CITY OF ALBUQUERQUE

Re: Newlife Homes Sundowner, 6101 Central Ave. NE, Grading and Drainage Plan, Engineer's Stamp dated 07-24-12 (K-18/D103)

GRADING AND DRAINAGE PLAN
 NEWLIFE HOMES
 SUNDOWNER

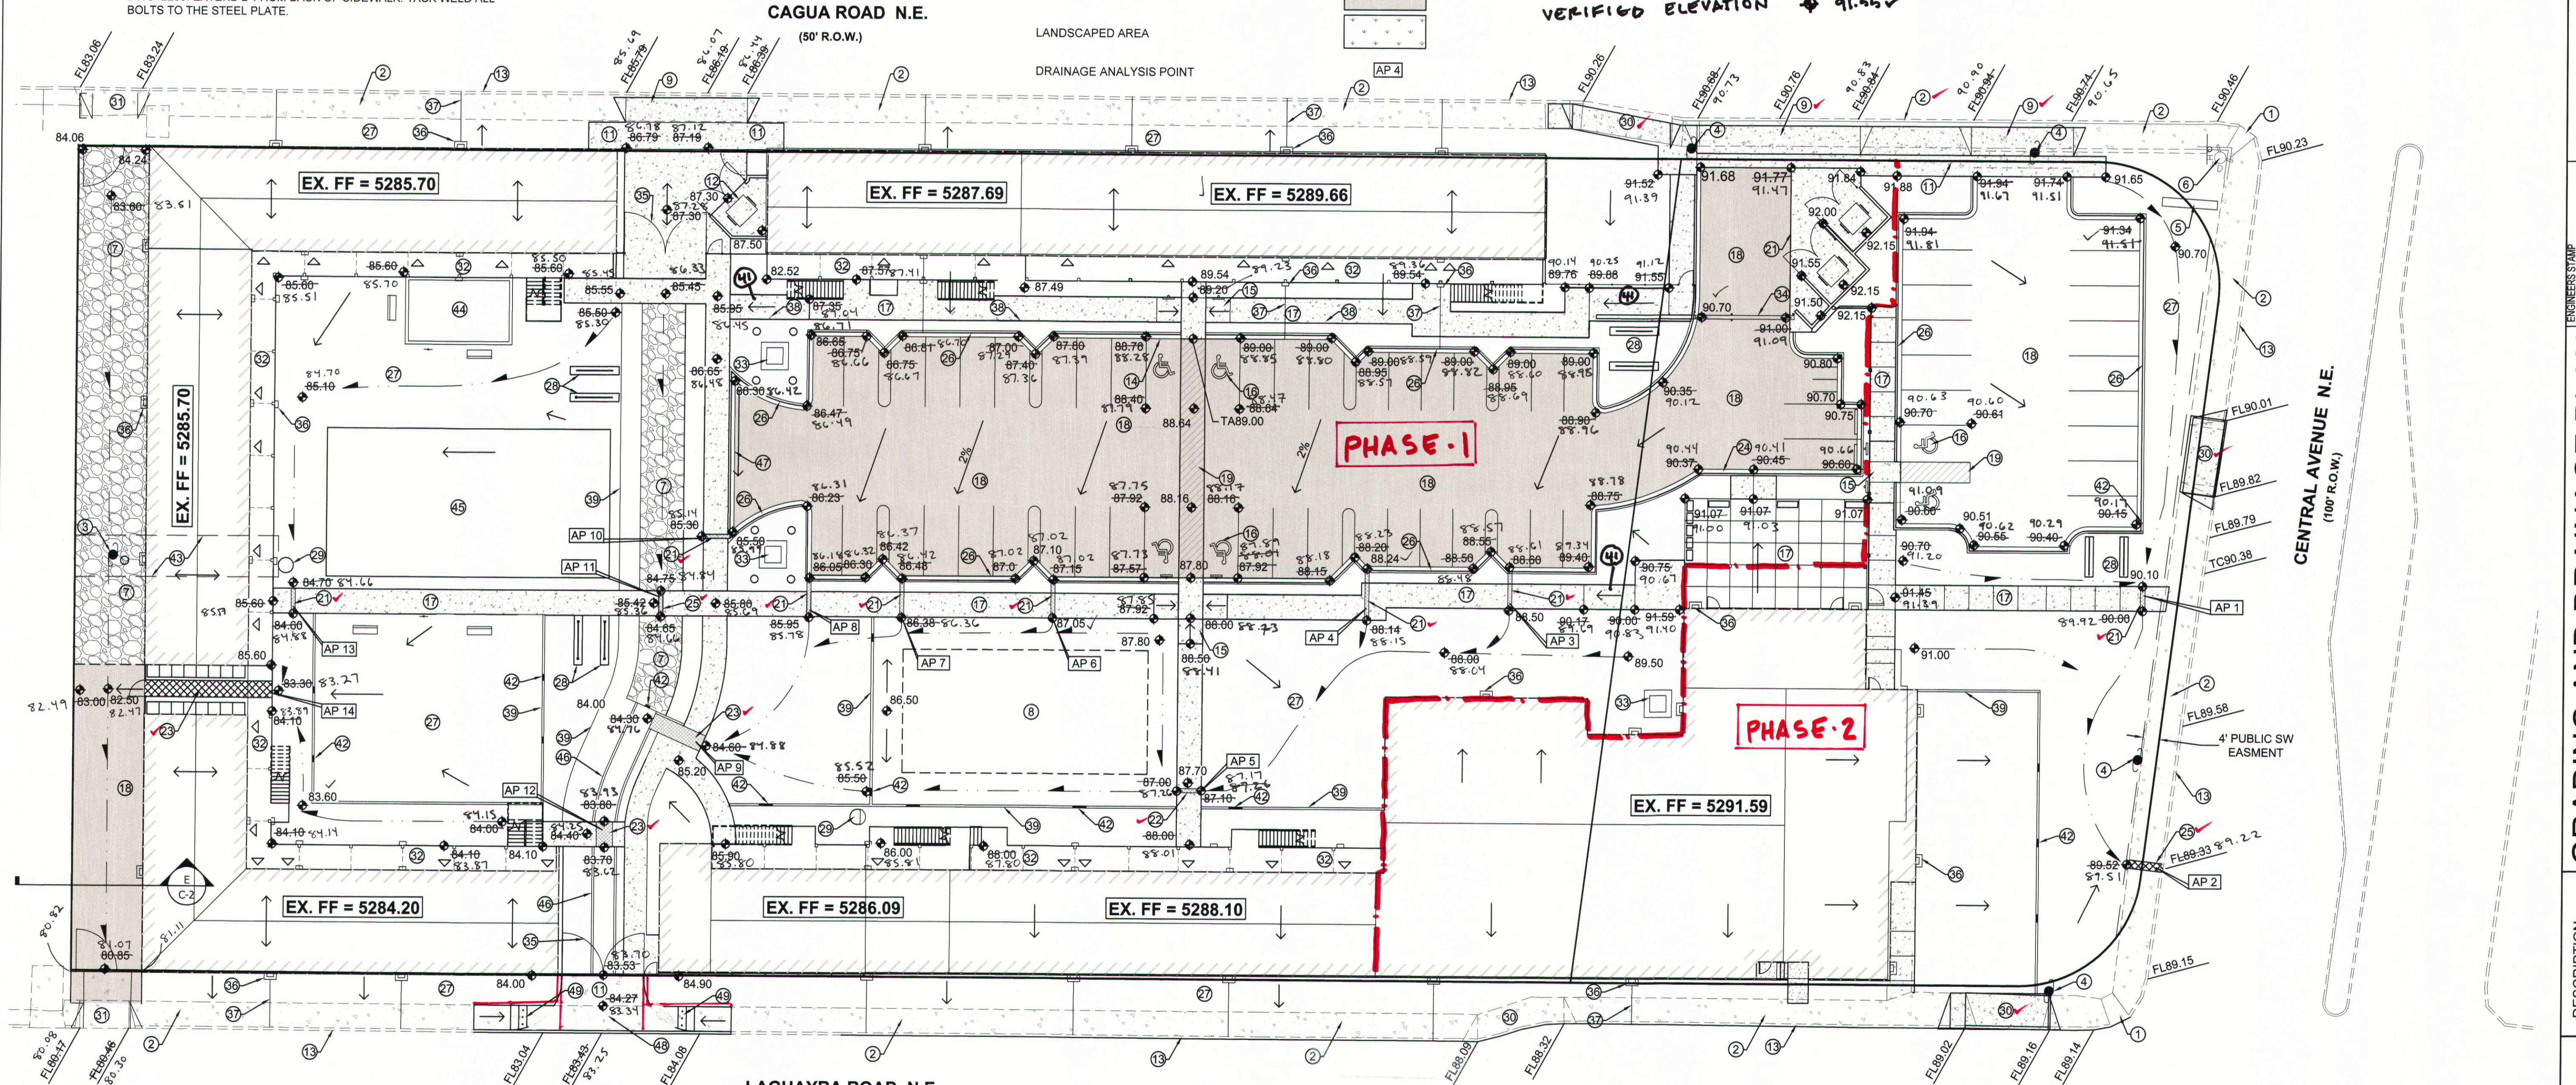
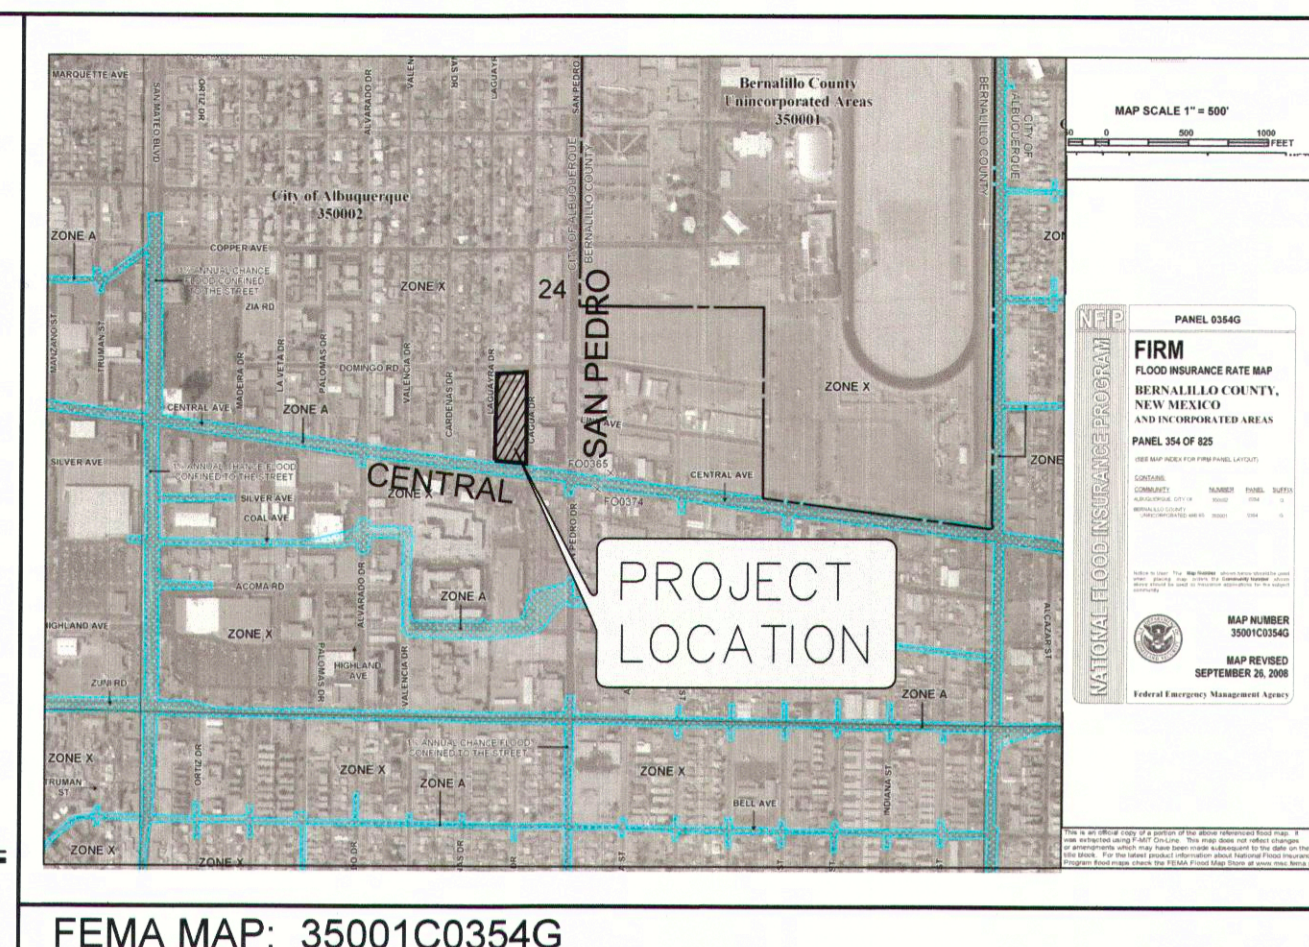
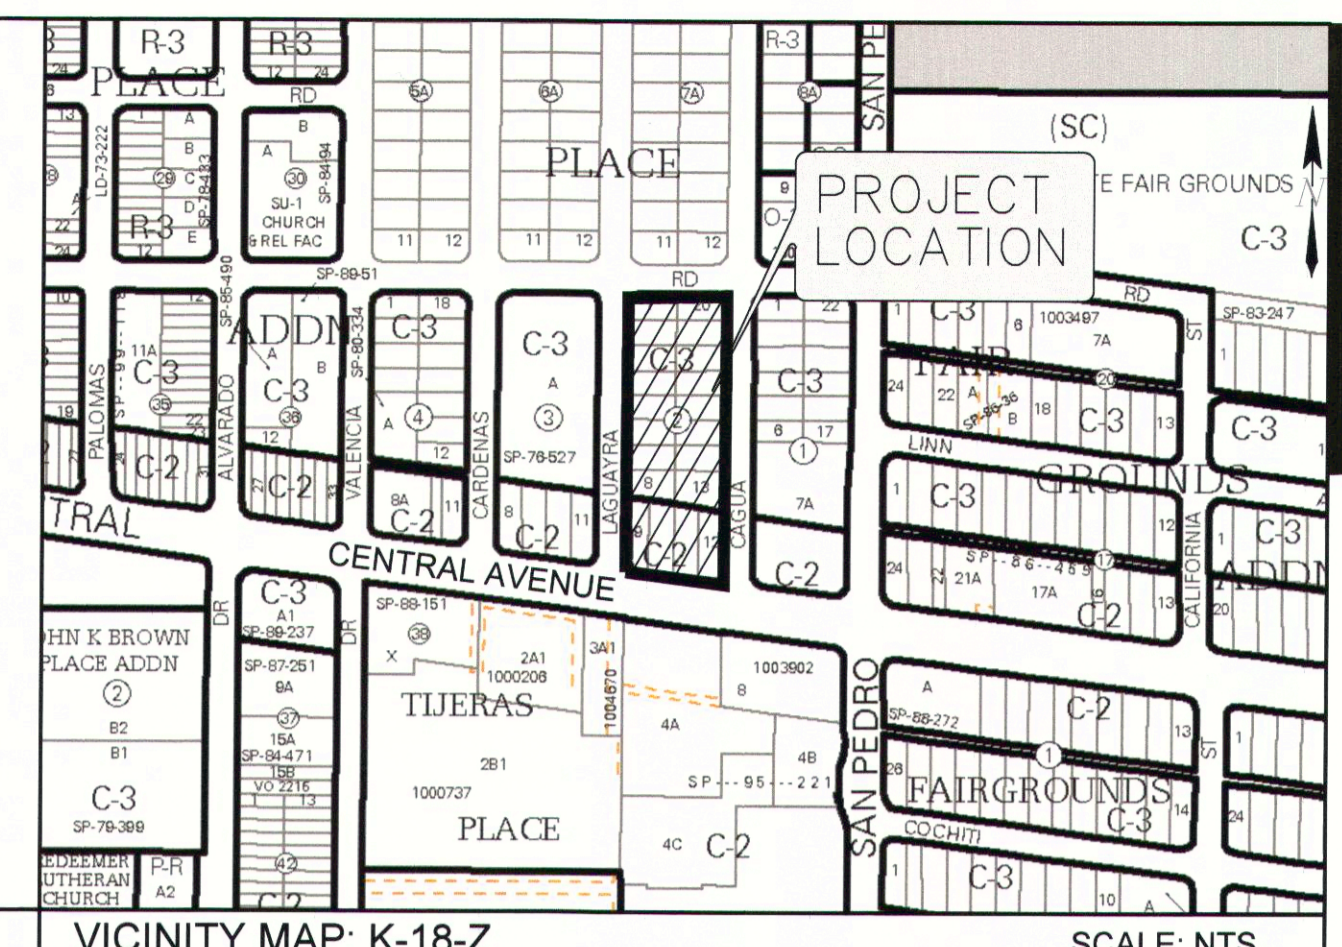
- Please show all ponding areas and provide volume calculations for each pond.
- Hydrology would prefer that flows within the main parking area be directed through the ponding areas that are being provided.

- Provide finished floor elevations for all buildings on the site.
- The property line is not shown clearly and it appears that the sidewalks are encroaching upon private property.

- Provide curb openings at the western edge of the southern parking area to allow flows to pass into the depressed landscape area.
- Keyed note #25 should include the note "tack weld all bolts to the steel plate" and this culvert should extend 2 feet north from the back of sidewalk.

- Include sidewalk culvert capacity calculations and state the flow that this culvert will carry to Central Avenue.
- Provide top-of-wall and bottom-of-wall elevations for the proposed retaining wall as well as a detail of the wall in the plan.
